From: Jo Edwards

Subject: App Ref: F/4/20/OUT - Ford Airfield, Ford Road, BN18 0FL Sport England Ref: PA/20/SE/AR/54998

FIGURE 5. ILLUSTRATIVE MASTERPLAN

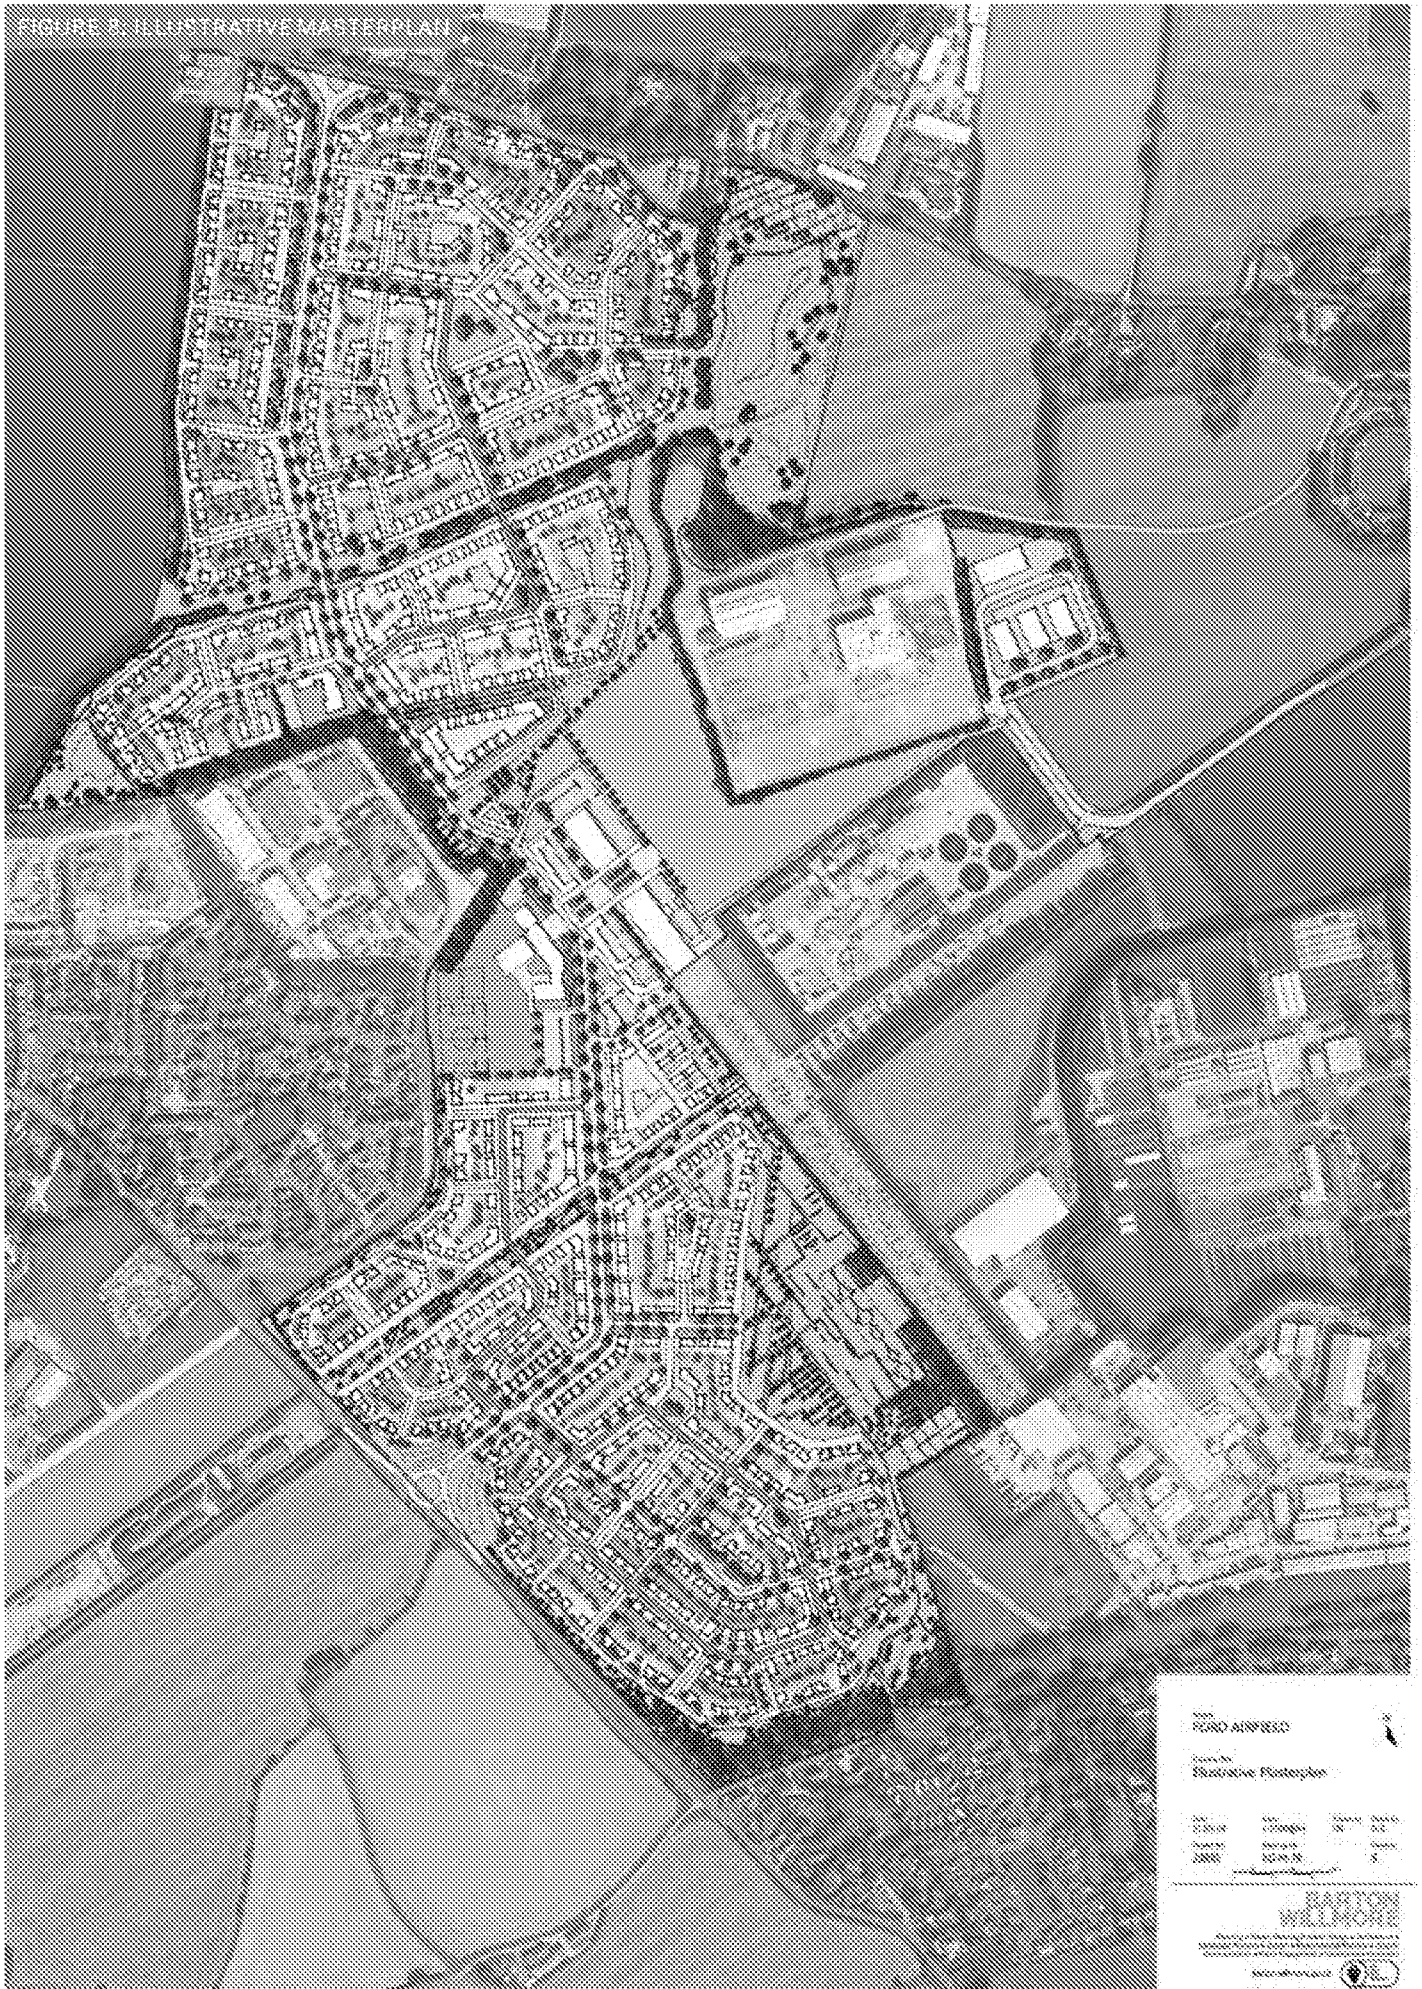
Thank you for reconsulting Sport England on the outline application. The only further comment I'd wish to make at this stage, further to our substantive comments made on 20/3/2020 is that with regard to the Green and Blue Infrastructure Plan, the alignment of the Arundel to Chichester canal through the area identified for sports pitches would possibly compromise the functionality of the site for formal sports. Clarification is required as to what is proposed in terms of reflecting the canal in the layout. I also note that there is no indication of the canal on the illustrative masterplan.
